Knockshanvo Wind Farm

Stage 1 Road Safety Audit

Futureenergy Ireland

June 2024

3m x 220m visibility splays

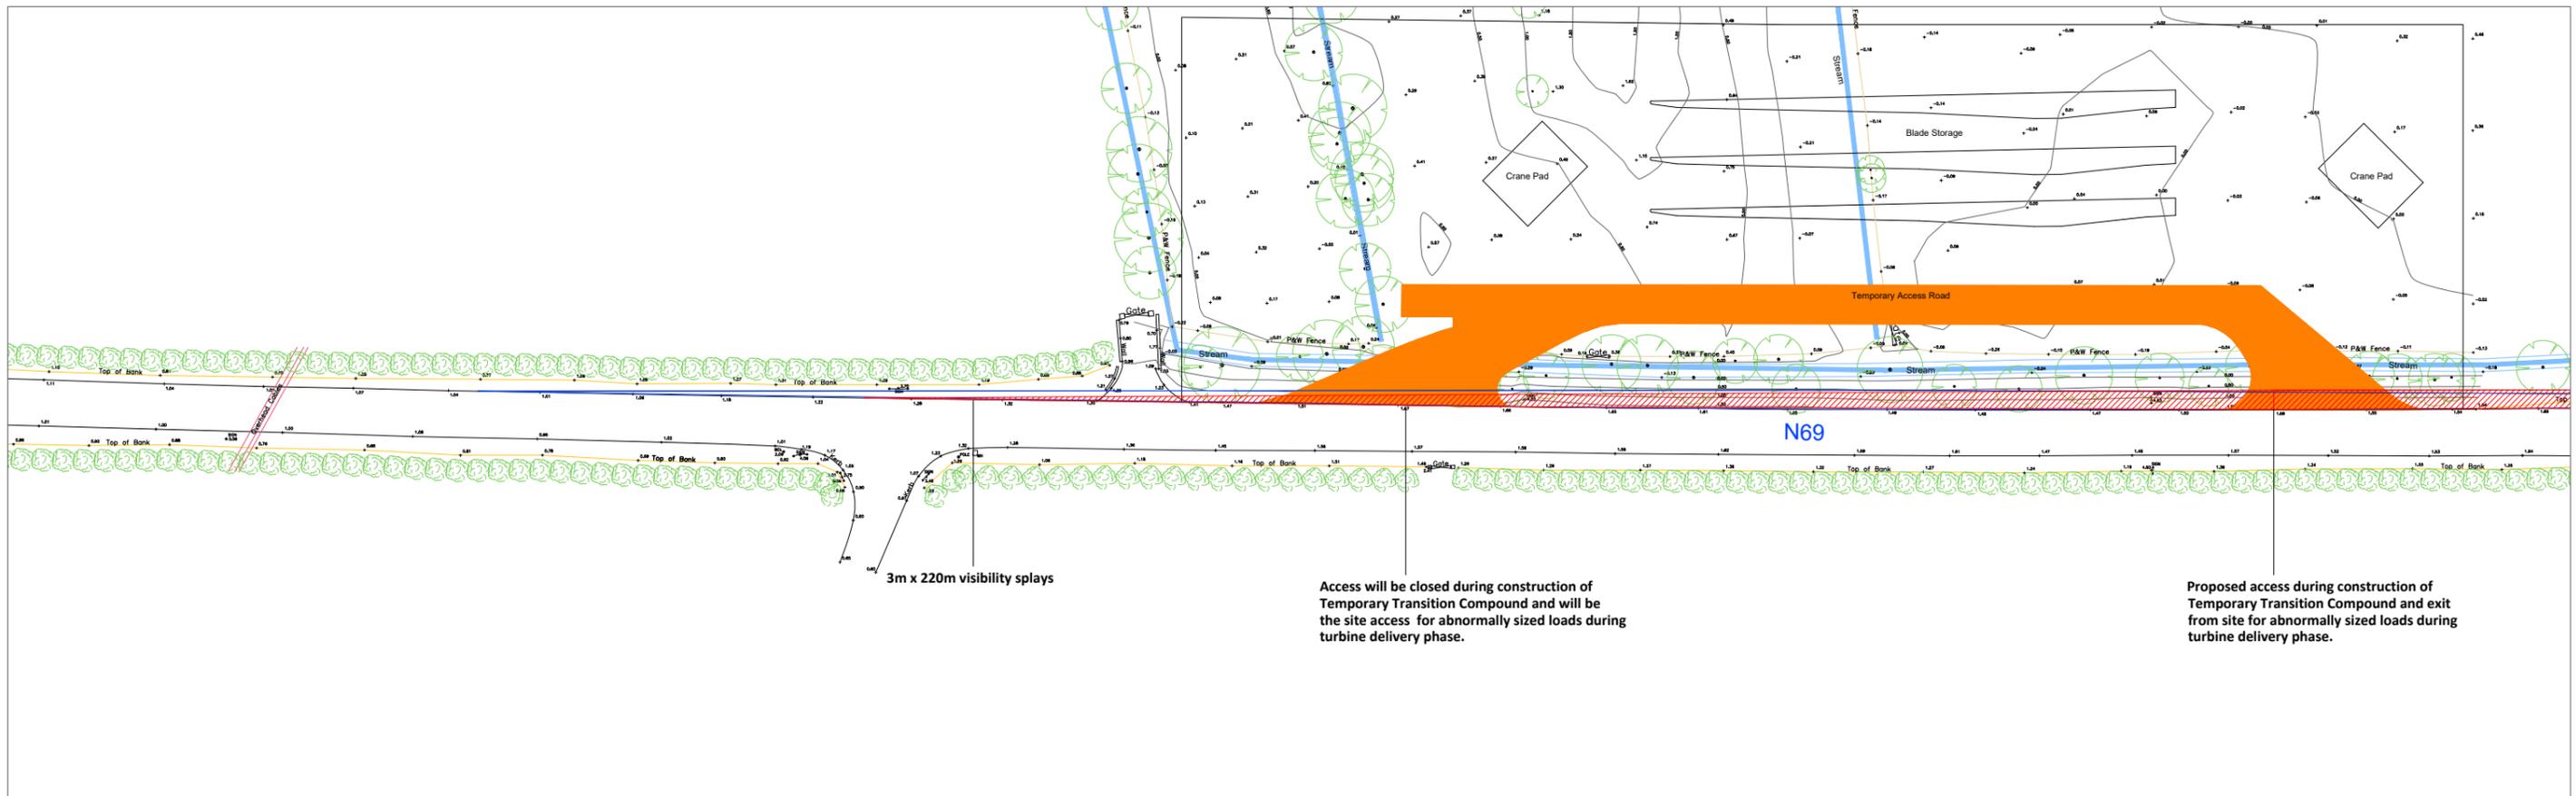
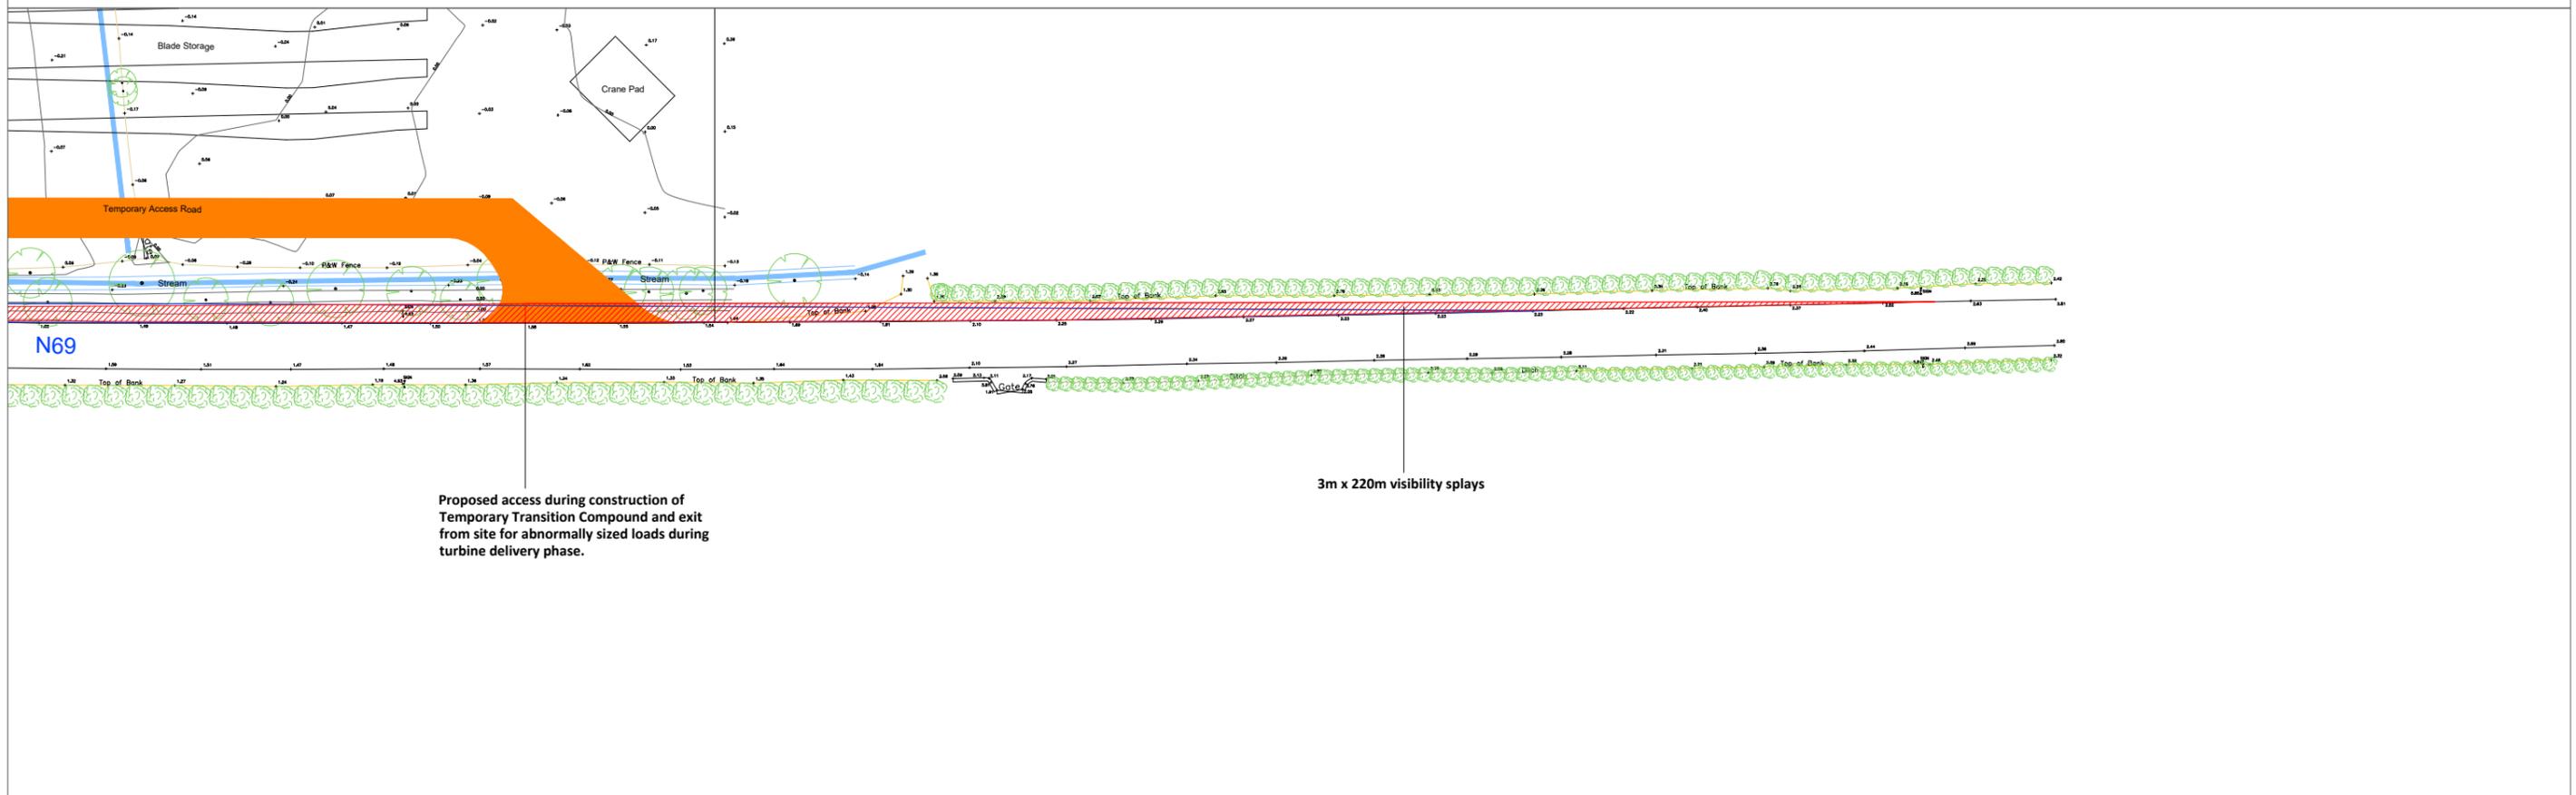
Sightlines to the left appear to be partially obscured by the existing field boundary, which includes ditch foliage and some trees. This could lead to side impact type collisions within the access junction's conflict zone.

The ditch should be modified to ensure that an appropriate sightline is provided at the location described.

It is acknowledged that visibility splays are constrained at the location of the proposed Temporary Transition Compound. Appropriate traffic management measures are set out in Section 15.1.2.3 of the EIAR. During the construction of the proposed TTC access to and from the site off the N69 will be controlled by traffic management measures, including temporary signage in accordance with the “Traffic Signs Manual, Section 8 – Temporary Traffic Measures and Signs for Road Works” (DoT now DoTT&S) and “Guidance for the Control and Management of Traffic at Roadworks” (DoTT&S). Construction staff (flagman) will be present at this location during all times that deliveries are made to and from the site. The site will be closed to all traffic by means of fencing at all other times.
